# CITY OF ALBUQUERQUE

PLANNING DEPARTMENT – Development Review Services

RE: **Applebee's at Holly Place** **B13-D022A**  
North Alb. Acres, Tract A, Unit B, Block 18, Lot 20 & Holly Place, Tract B  
Conceptual Grading & Drainage Plan for Site Development Plan,  
Grading Permit and Building Permit **PE Stamp: 9/20/2013**

2 ROCK SWALE

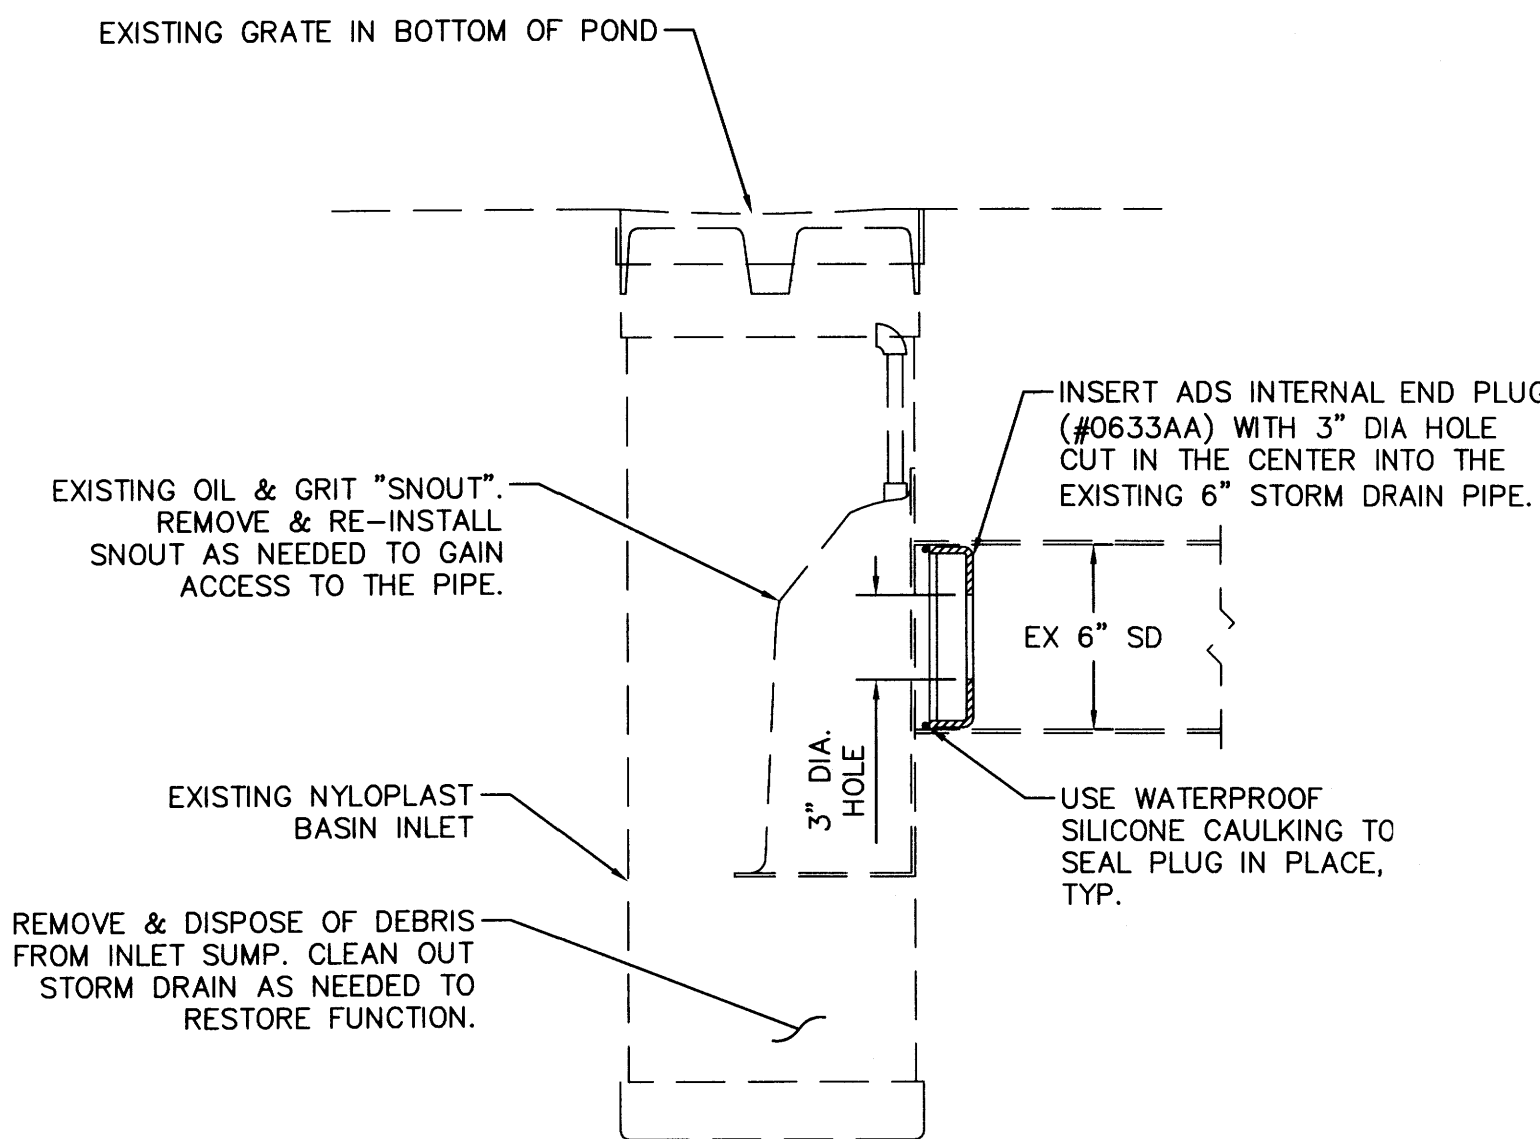
4. Label the new basin discharge points and rates at detention pond inlets and outlets, and where flows enter and leave the site.
5. CG-501: Dimension the thickness on the Rock Swale, Detail 2.

drawing title
GRADING & DRAINAGE PLAN
drawing number
CG-101

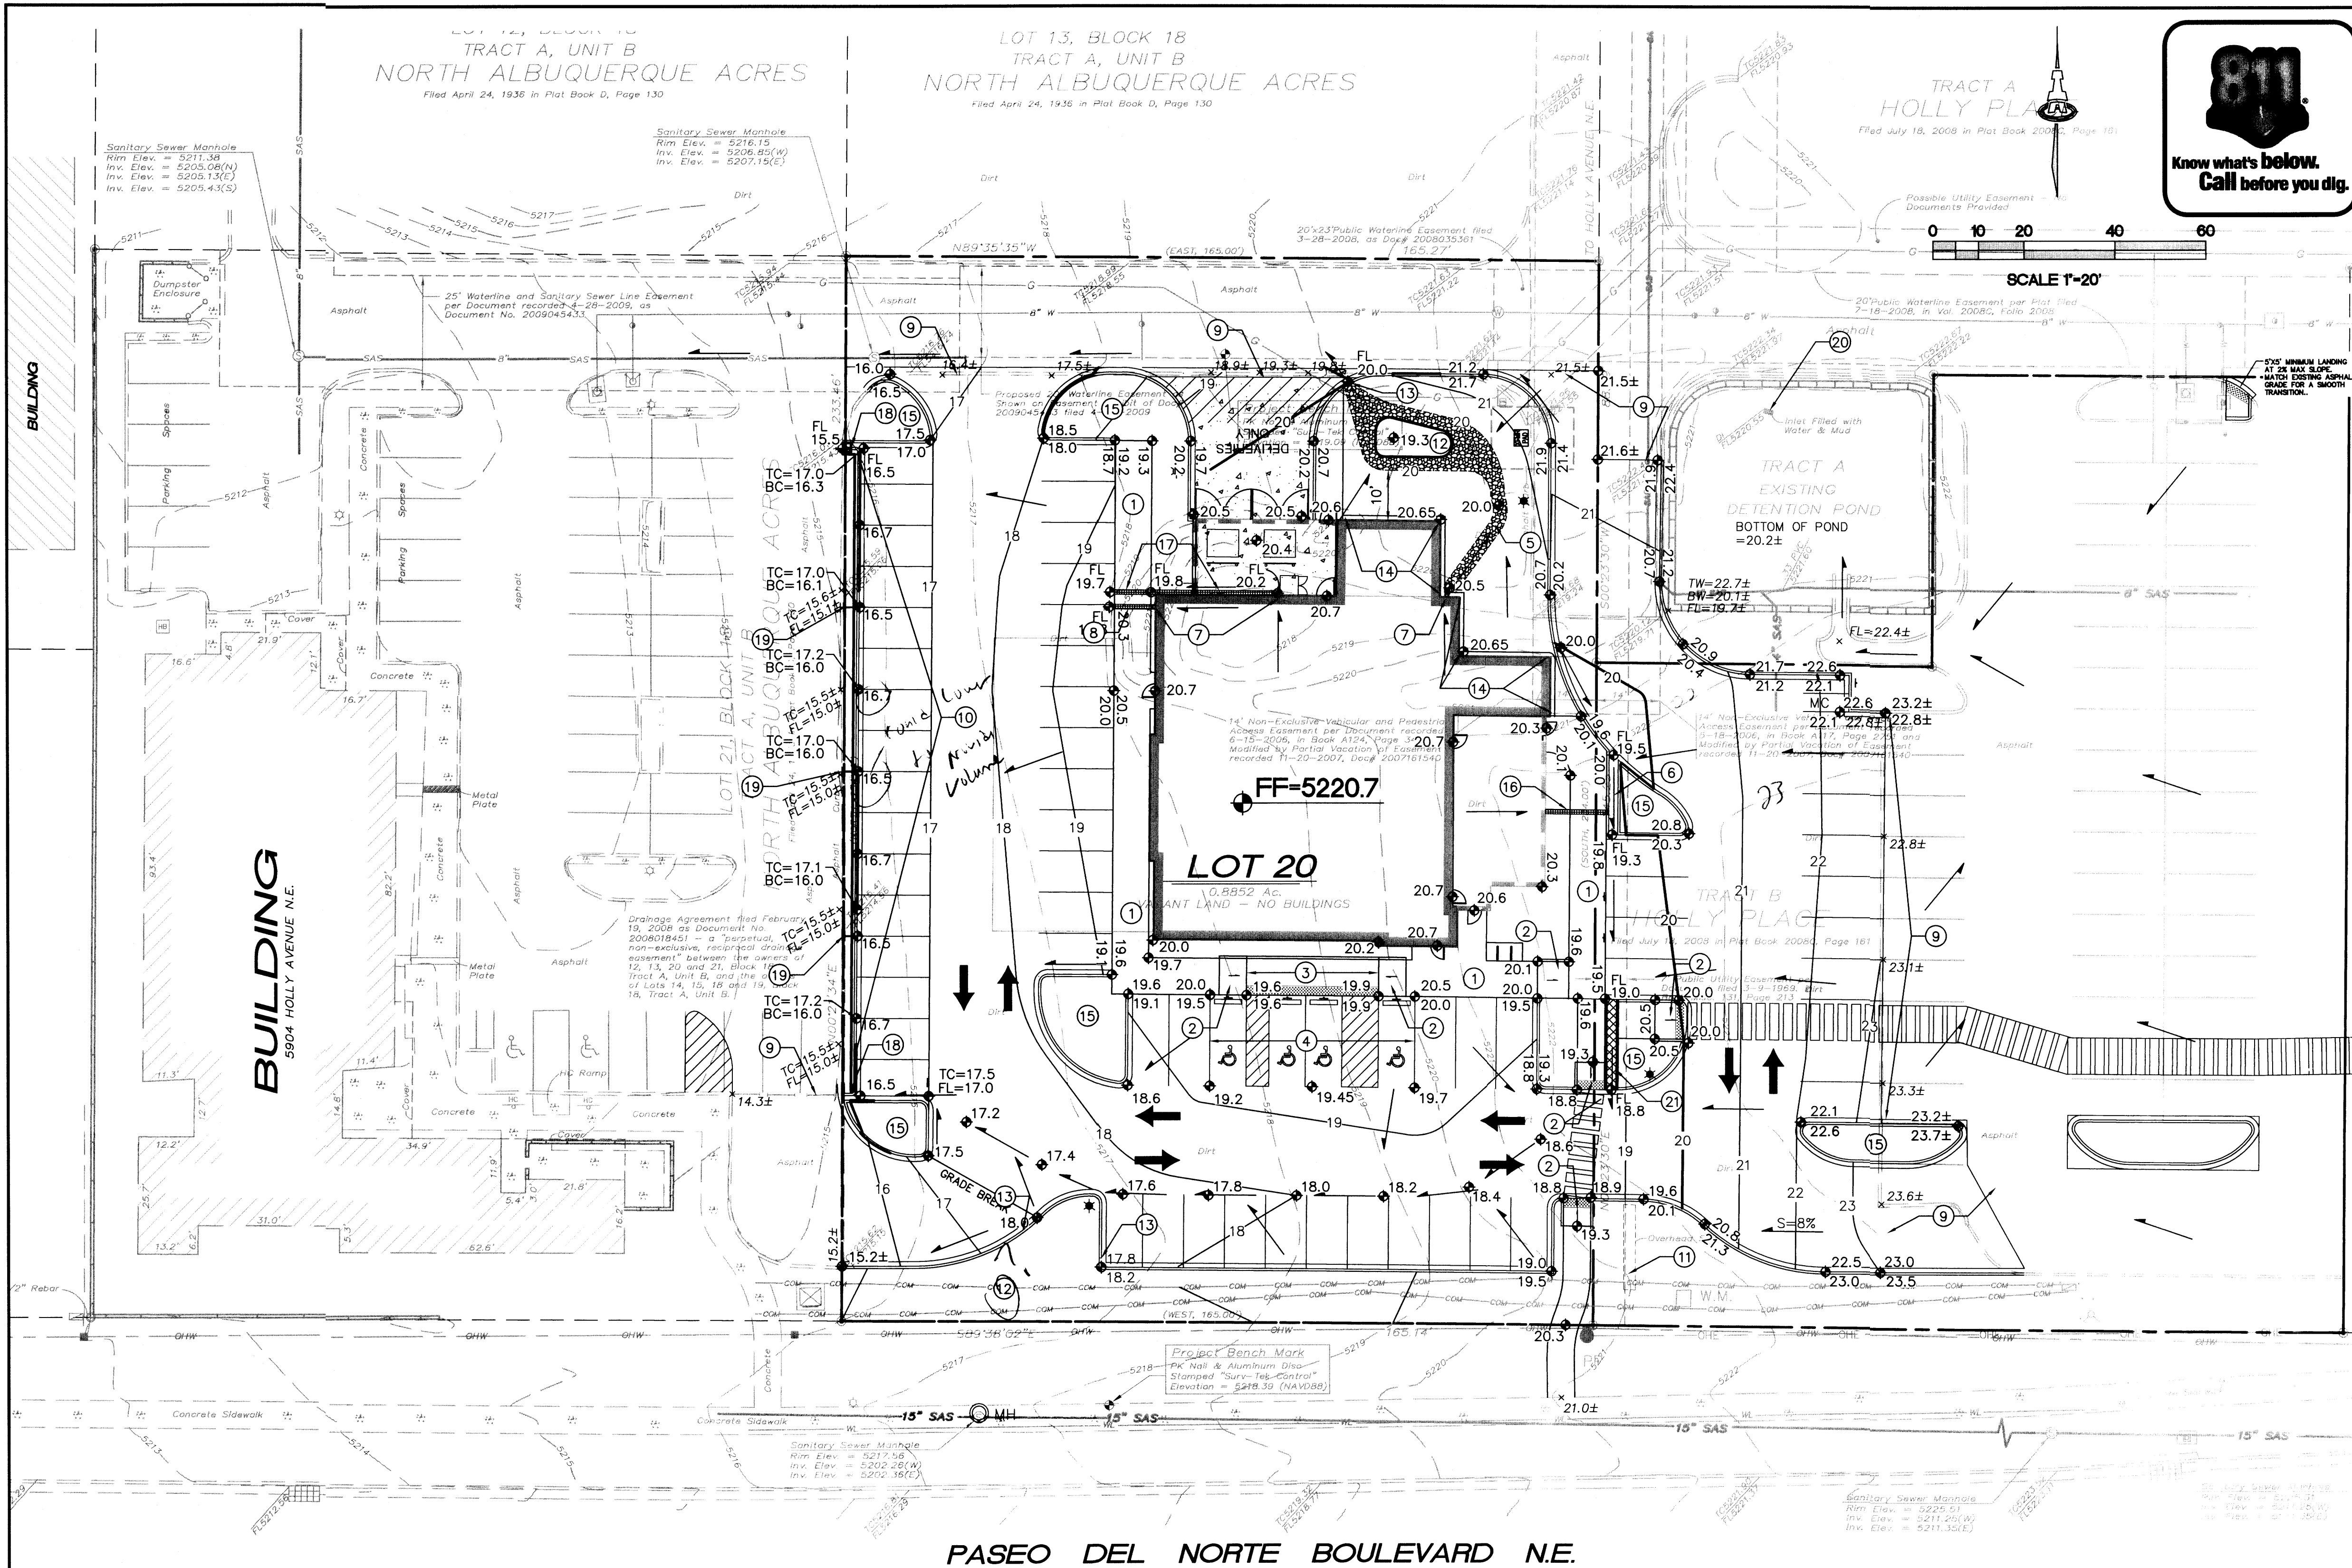
1. A portion of Tract B included in drainage Basins 1, 2 and 3, was master planned (*"Holly Place Commercial Phase II," 10/26/07 by Fred Arfman*) to drain to, and be detained in, the existing detention pond on Tract A. Routing of these additional flows through Applebee's site (Lot 20) will require detention prior to discharging onto Lot 21. Lot 21 and its outfall channel were designed with assumed runoff rate of 4.629 cfs/acre from Lot 20, only.
2. Revise your Basin map on CG-501 to show the "offsite" flows that enter Basin 5, which constitute the remainder of Sub-Basin 2 from the 2007 analysis. Basin 5 should also include the area of the existing detention pond. Revise calculations accordingly.
3. Refine the "PROJECT INFORMATION, Proposed Conditions:" on CG-101 to reflect the above constraints, rather than "FREE DISCHARGE."
